**CITY OF ALBUQUERQUE
PLANNING DEPARTMENT
April 24, 2013
DRB Comments**

ITEM # 7

PROJECT # 1009178 APPLICATION # 13-70512

RE: Lot 31, Block 9, Volcano Cliffs Unit 18

SKETCH PLAT
TIBURON HEIGHTS
 WITHIN THE
 CITY OF ALBUQUERQUE
 BERNALILLO COUNTY, NEW MEXICO
 OCTOBER, 2012

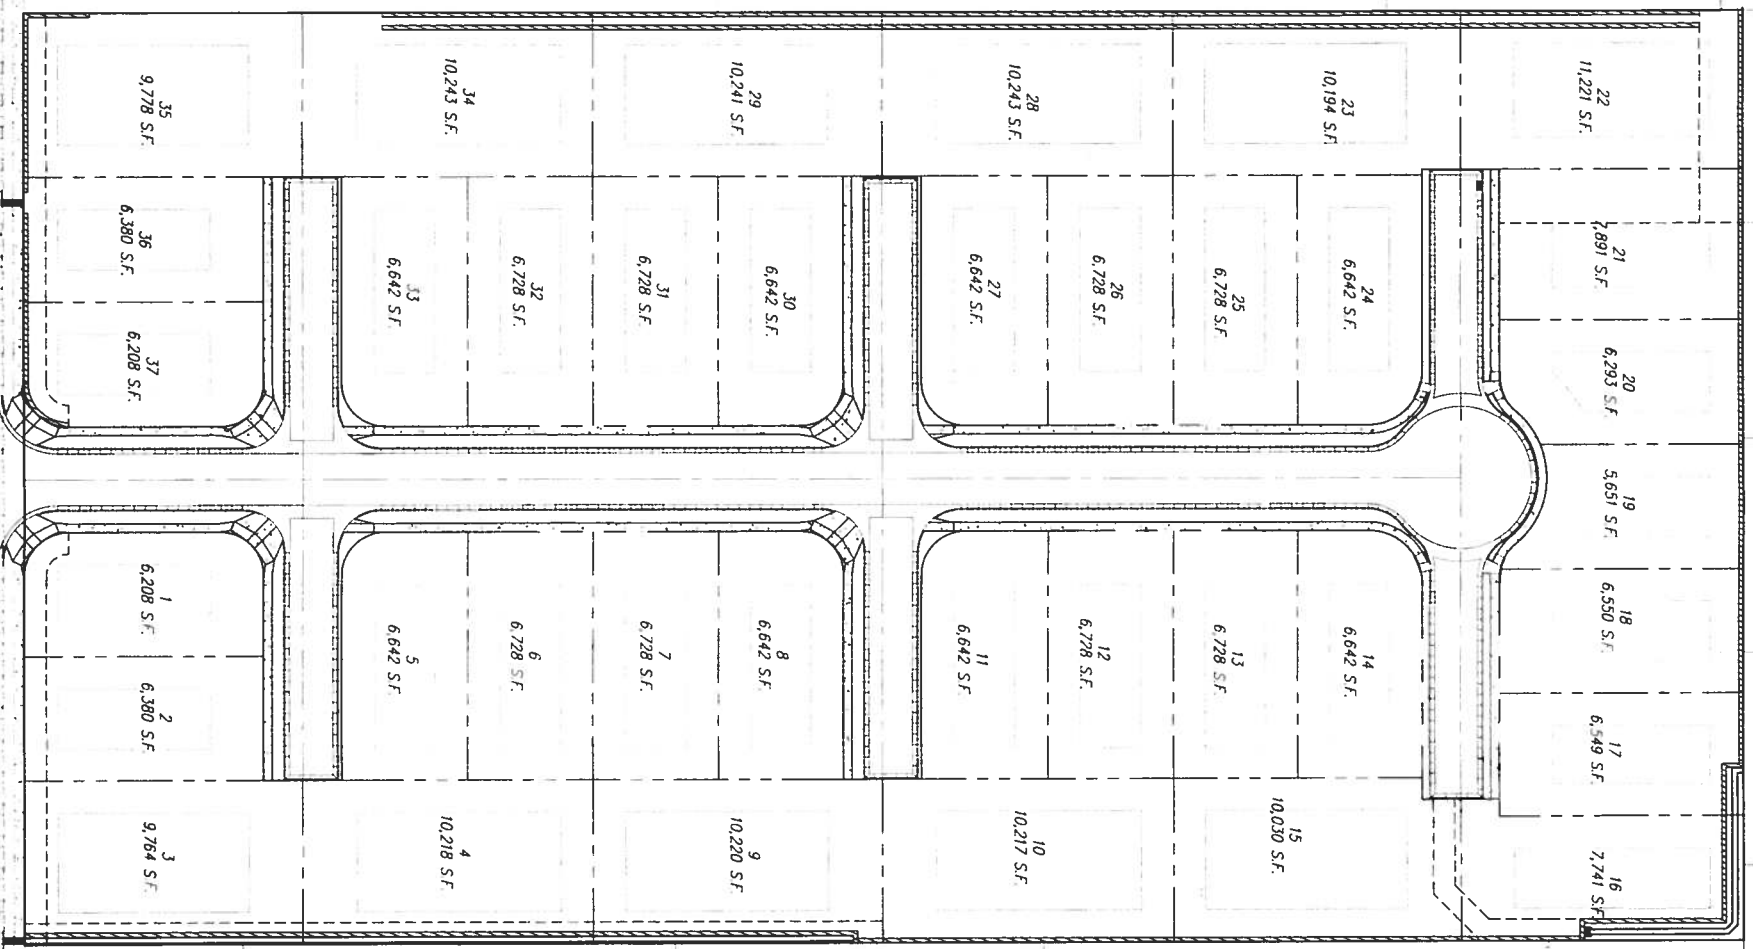
New dead-end streets and cul de sacs are prohibited by the sector plan – a looped road is required. Additionally, proposed streets do not appear to meet Transportation Regulations of the sector plan for Sidewalk Width and ROW width; detailed design criteria will be required to demonstrate compliance.
